From:
Sent: 05 October 2023 22:14
To: DCAdmin
Subject: 2023/92467

Notice of proposed planning application at No. 18 New Avenue, HD50JD **Ref: 2023/92467**

PROPOSED SITE PLAN
1 : 100

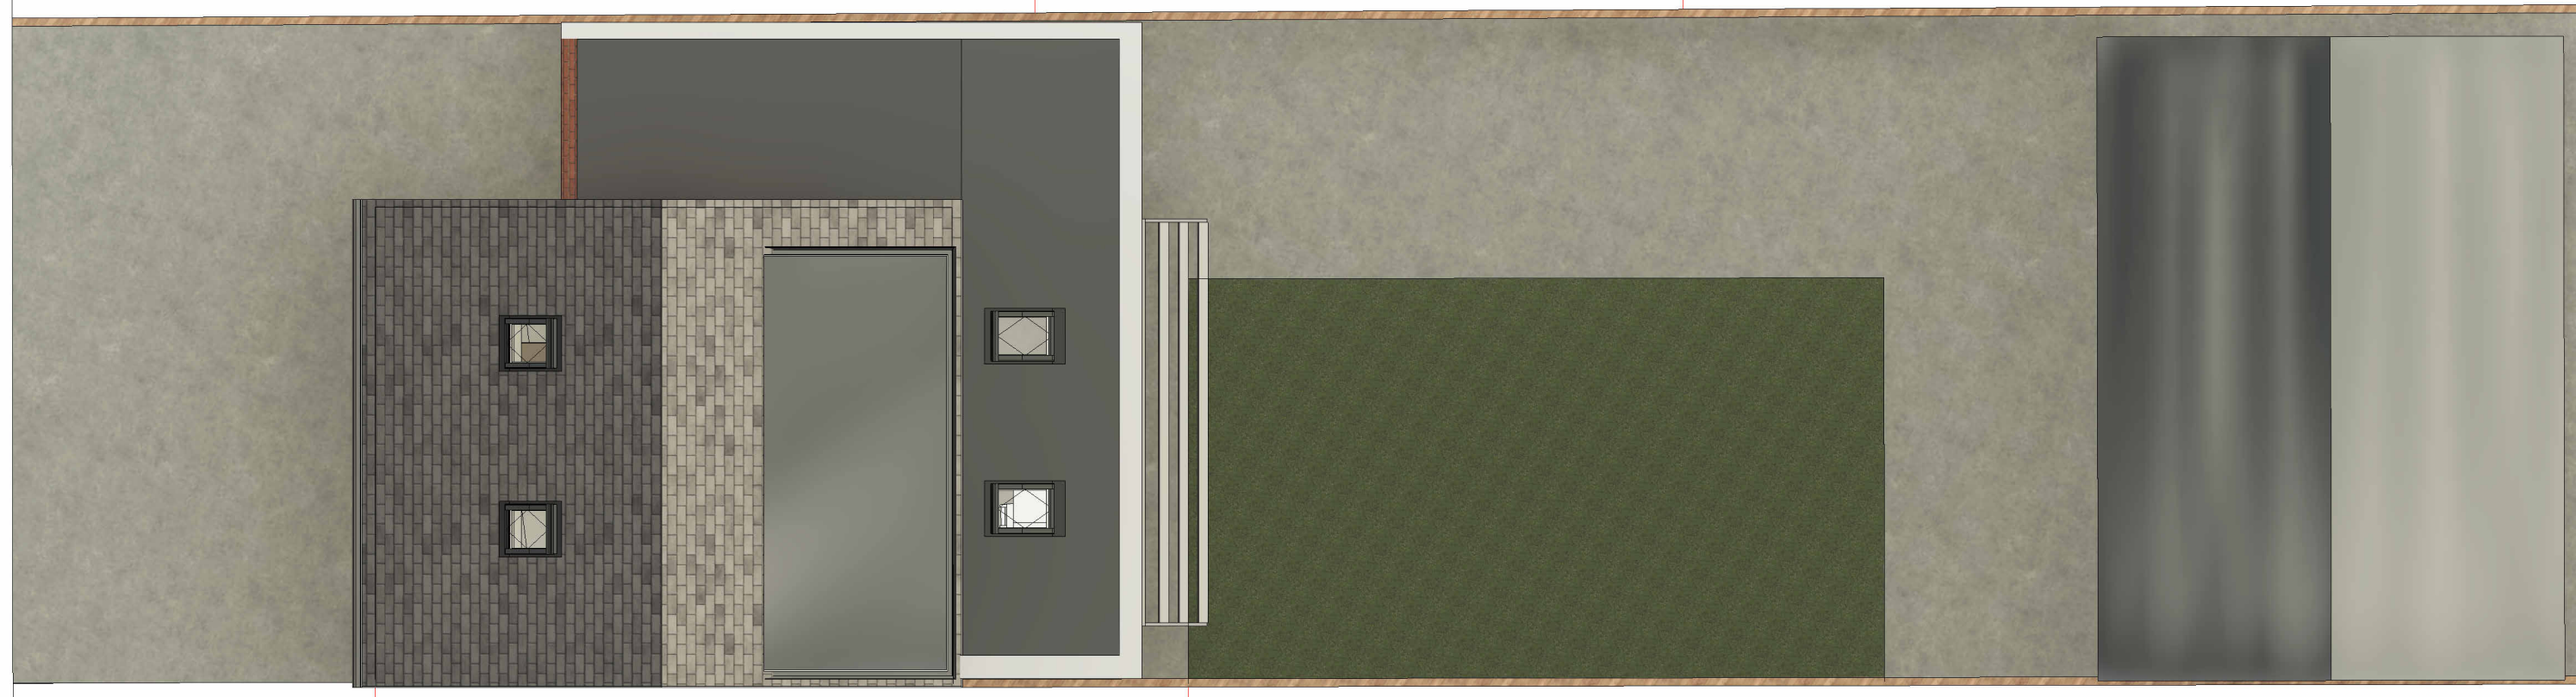
Although the proposal claims that no trees or hedges will be removed, the current plans indicate otherwise, showing the extension coming right up to the boundary of my home. I am under the impression that at least 1 metre should be left in this instance. According to my house deeds it clearly states I have boundary ownership with the relevant markings, the removal of the beech tree/hedge by my neighbour would require my permission.

Permitting the proposed development would leave the property with less than 50% of its original garden area, which was over 50 feet in length and approximately 20 feet wide. There would be no green space whatsoever left. This surely represents an excessive level of overdevelopment.

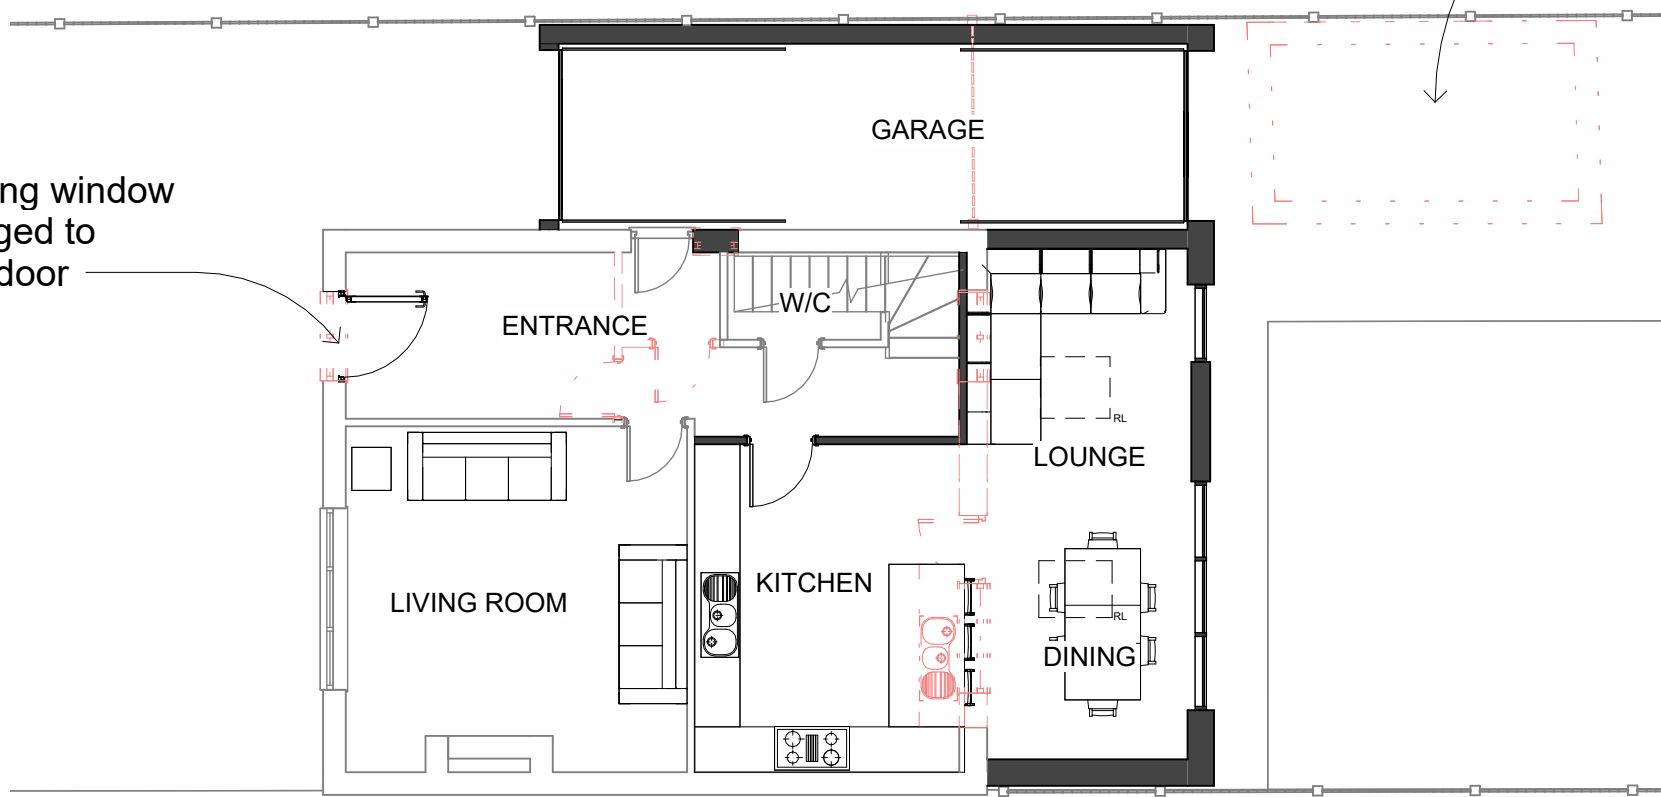
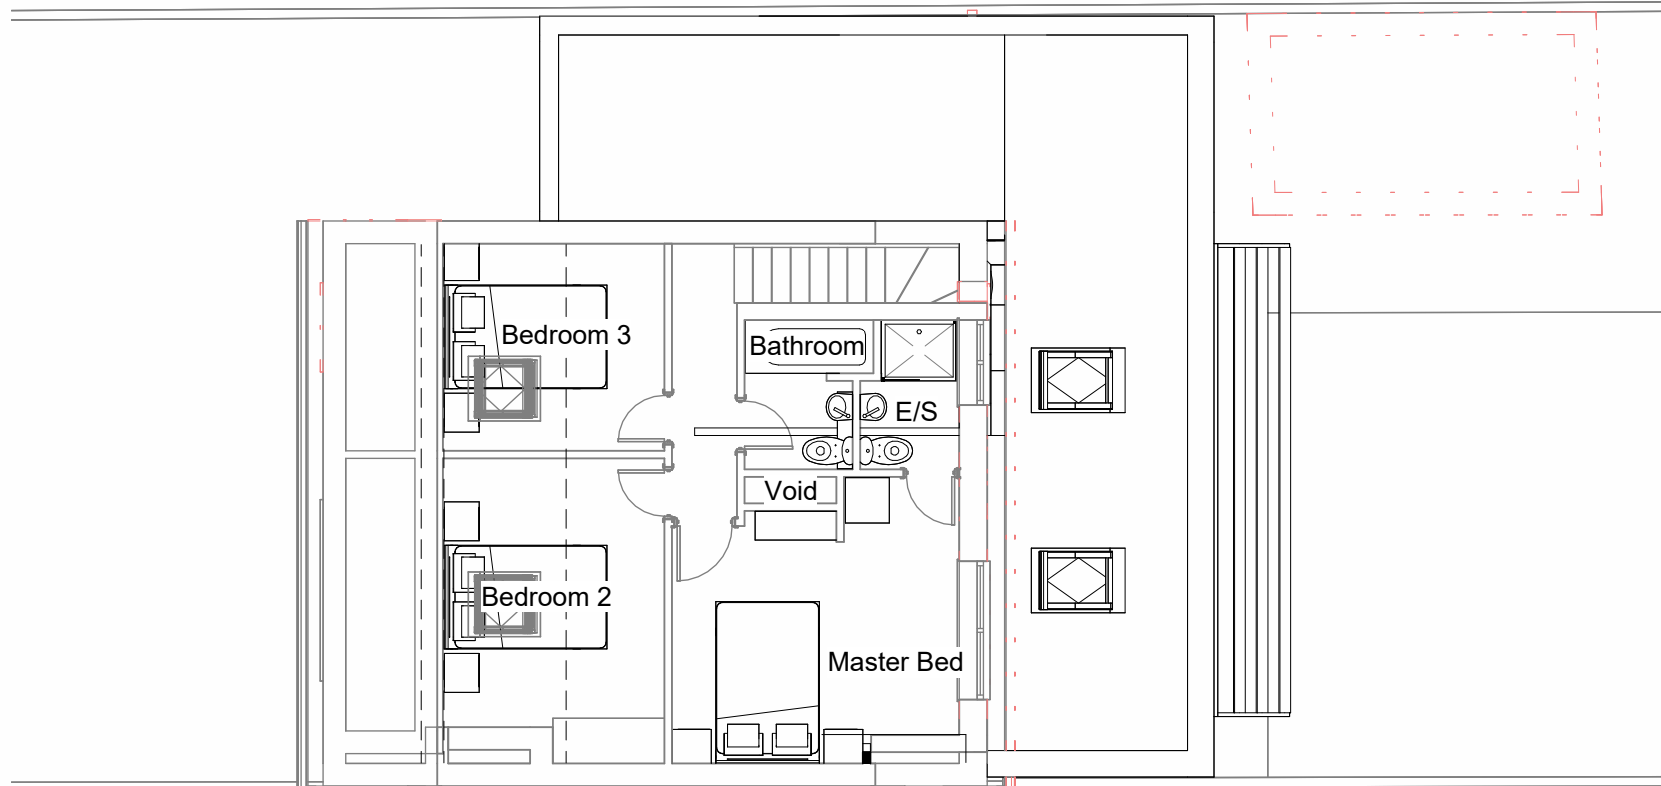
The existing conservatory on the rear of our home will be overshadowed losing light and changing the view by any further building works at number 18 if permitted up to the boundary of the property. The proposed building would be overbearing and will significantly diminish the amount of light affecting the liveability and enjoyment of these spaces, together with the increased noise level associated with such a huge social area.

According to legislation that mandates leaving a 1-meter gap from the boundary for side extensions the properties on New Avenue, particularly the front view (North East elevation), were built in the 1960s with extremely narrow driveways. The garages were positioned to the rear, away from the main building of the houses to allow for access. Incorporating a wide enough garage to accommodate a car with access granted around the property is not feasible. If there is no access, the only available route to the rear of this property would be through the main house, further resembling terraced houses.

Granting permission for the development would result in the house no longer aligning with the architectural style of the other bungalows on the avenue. The proposed changes would transform the property from a semi-detached home to a configuration resembling a terraced house, overlooking the neighboring property at number 20 and the removal of the mature beech hedging which the proposal states will not be removed.
